From: STEPHEN WHITEHEAD [REDACTED]
Sent: 03 March 2020 19:33
To: Planning.Responses <Planning.Responses@arun.gov.uk>
Cc: Maria Tomalova <Maria.Tomalova@arun.gov.uk>
Subject: Objection to BN/66/19/PL

Proposal to build two bungalows at Arun Place

Drainage Strategy Drawing

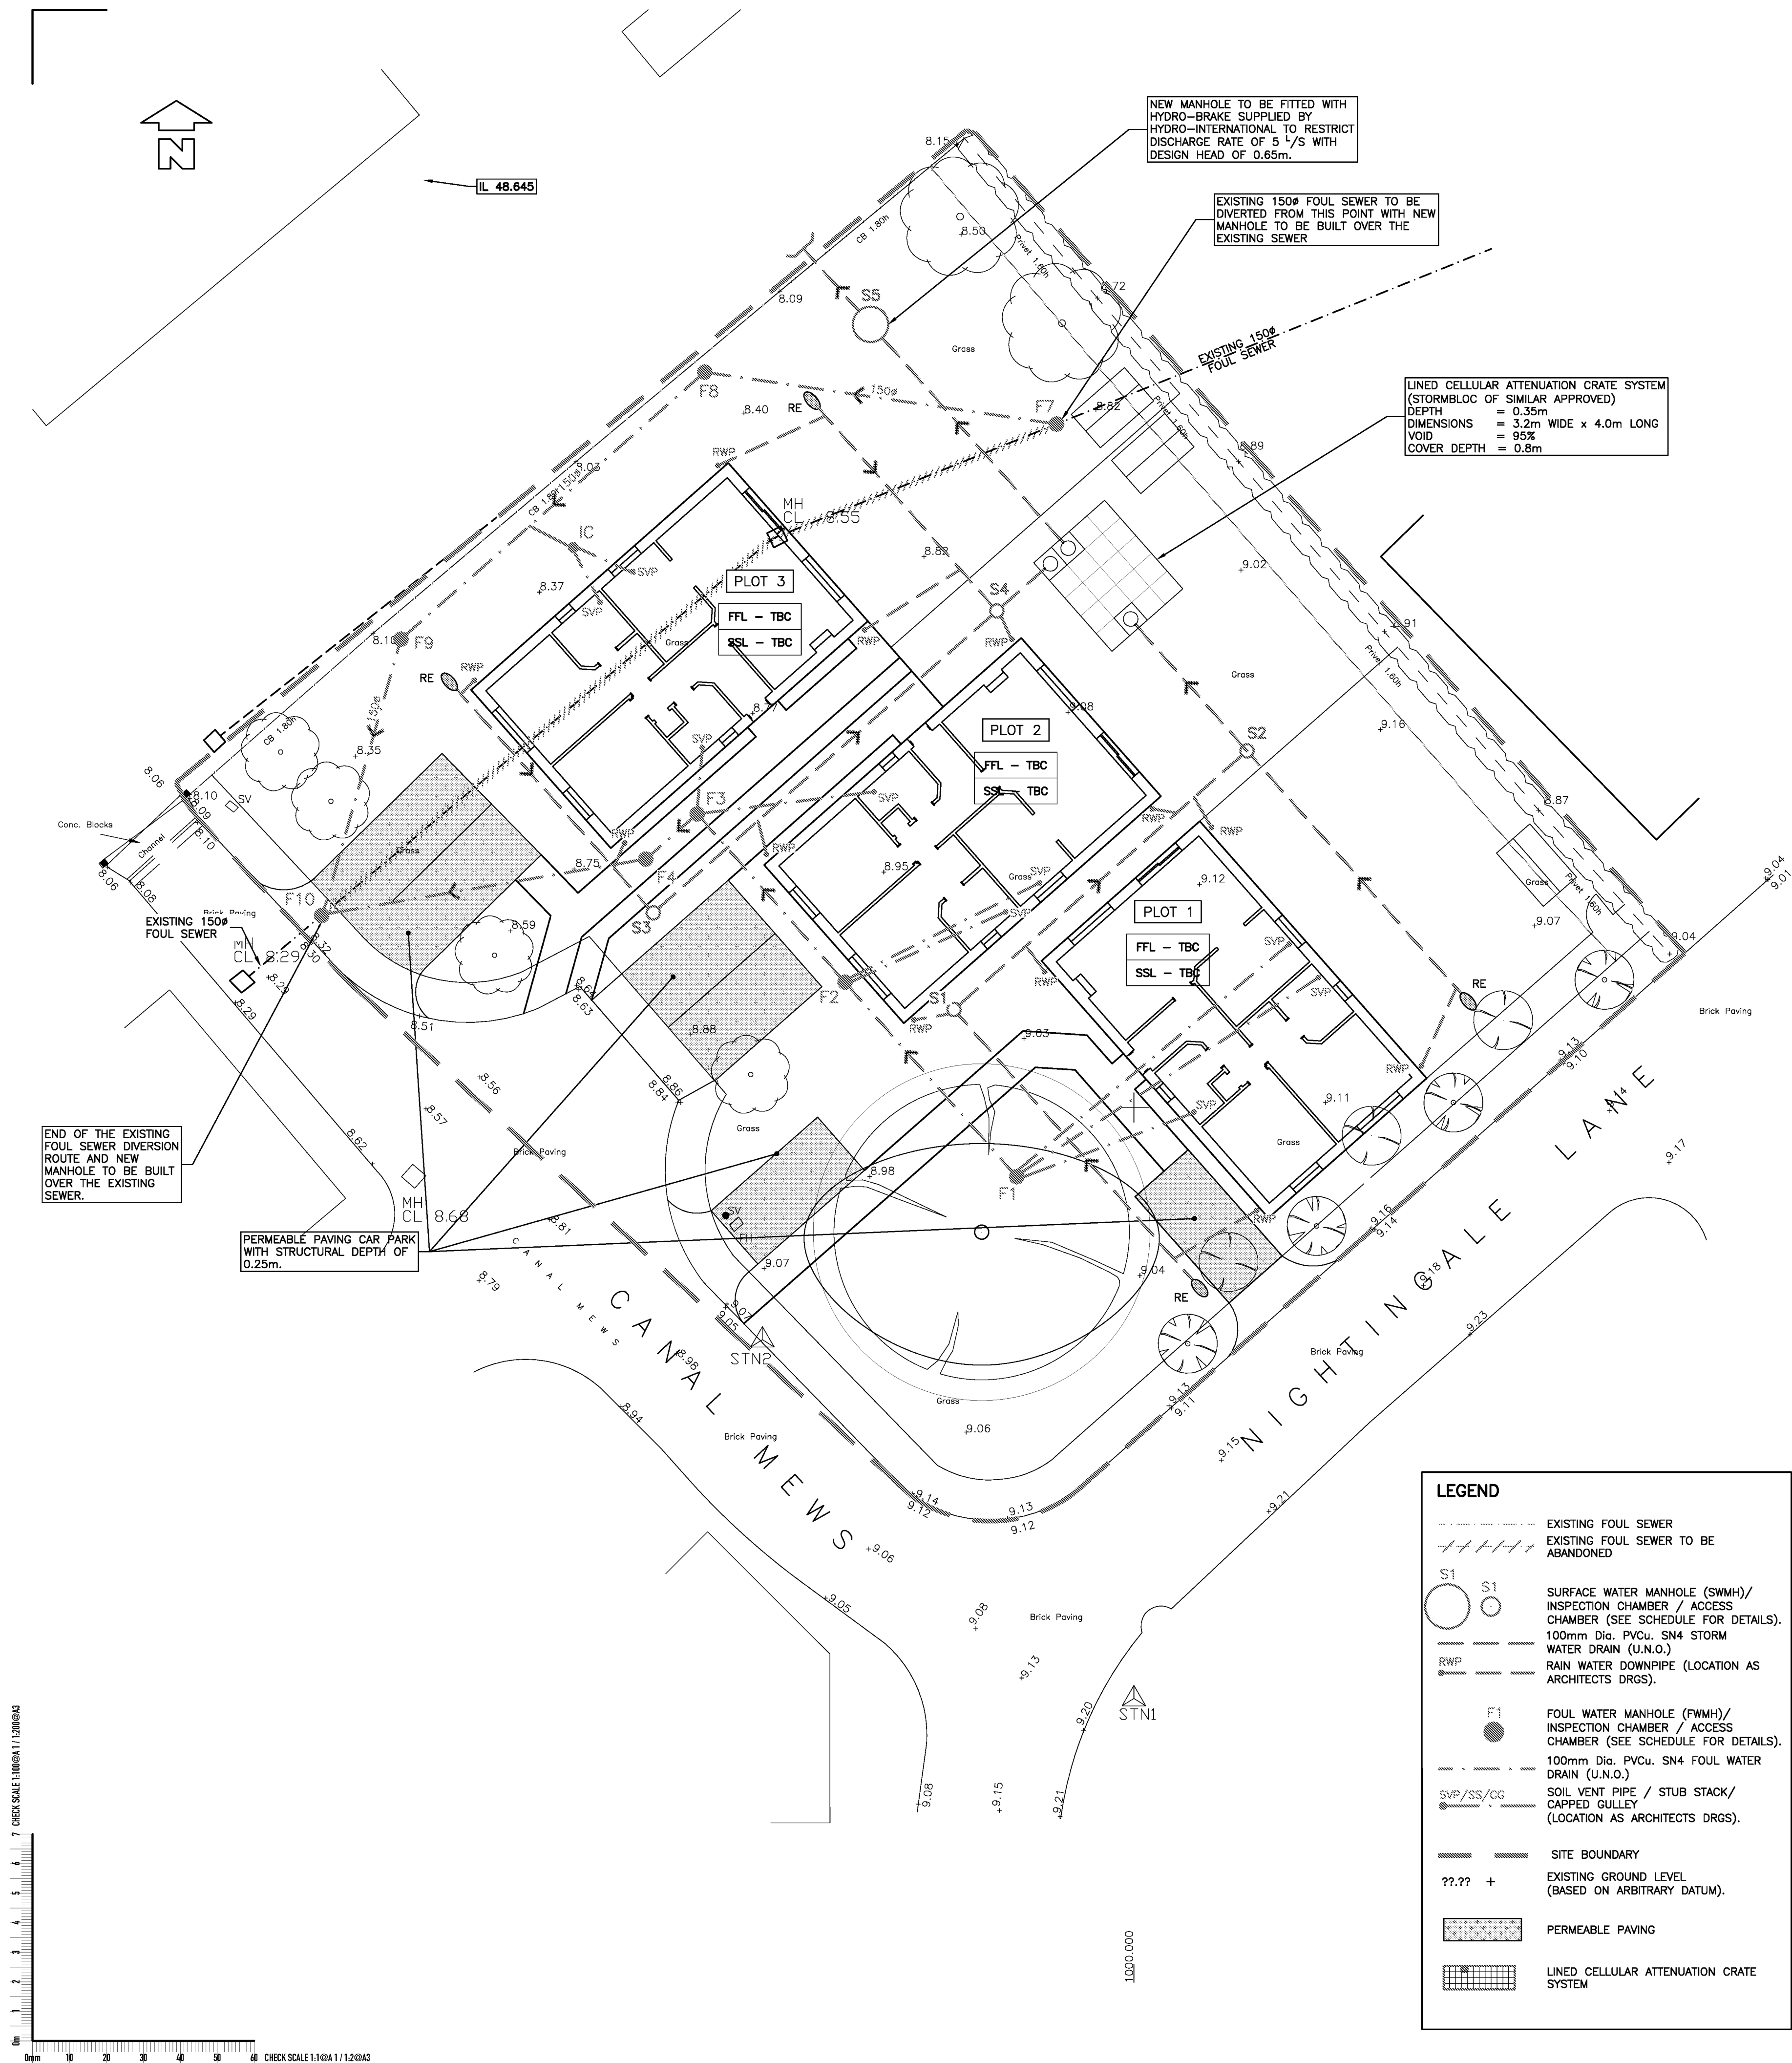
On the plan seaward propose to alter the sewer at 4 different connections. These connections are very tight constriction points, and I am extremely concerned with the last one (New manhole No3) whereby the plans show the last join sewage flow would be travelling South West, (uphill) whereas the water flow is actually in the opposite direction North West leading into the drain in Halliford Drive to join the main drain In Lake Lane. Therefore this proposal or alteration of our drains would cause the drains to back up.

What investigations have been done? Has an application been sought under Section 185 of the Water Industry Act 1991 in order to divert a public Sewer? More information and investigation is needed into this.
